CITY OF ALBUQUERQUE
Planning Department
DRB Comments
2/5/03

Project # 1002449

Application # 03DRB-00111

Subject: MRGCD Map 39/ Sketch Plat

SKETCH PLAT

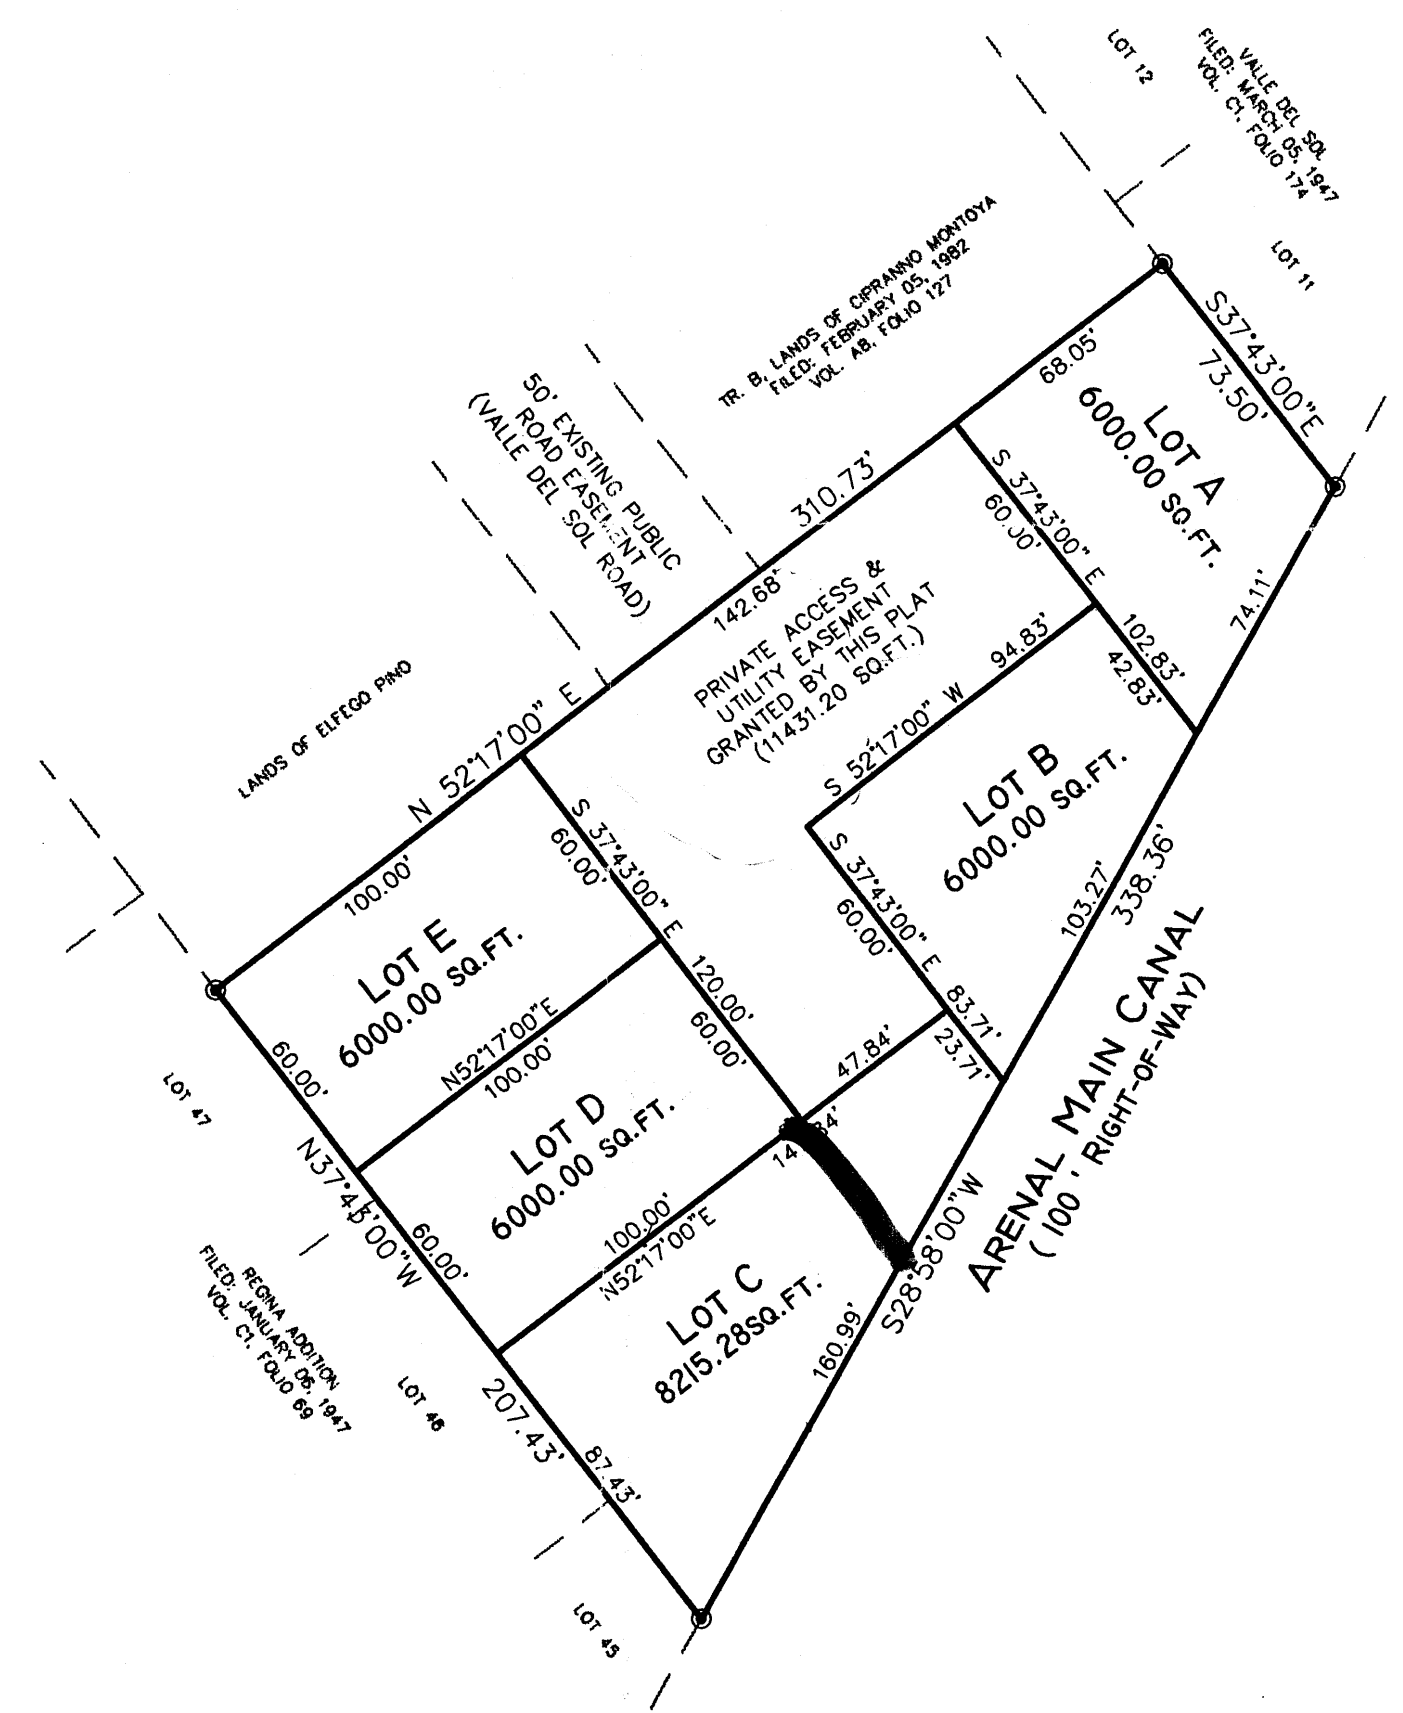
Lot C as shown does not meet the minimum 50' lot width requirement of the City Zoning Code. An alternate solution will be presented to the agent at the DRB meeting.

- A cul-de-sac needs to be provided for and constructed.
- How was it determined that Valle del Sol was a public road?

An approved drainage plan is required for Preliminary Plat approval.
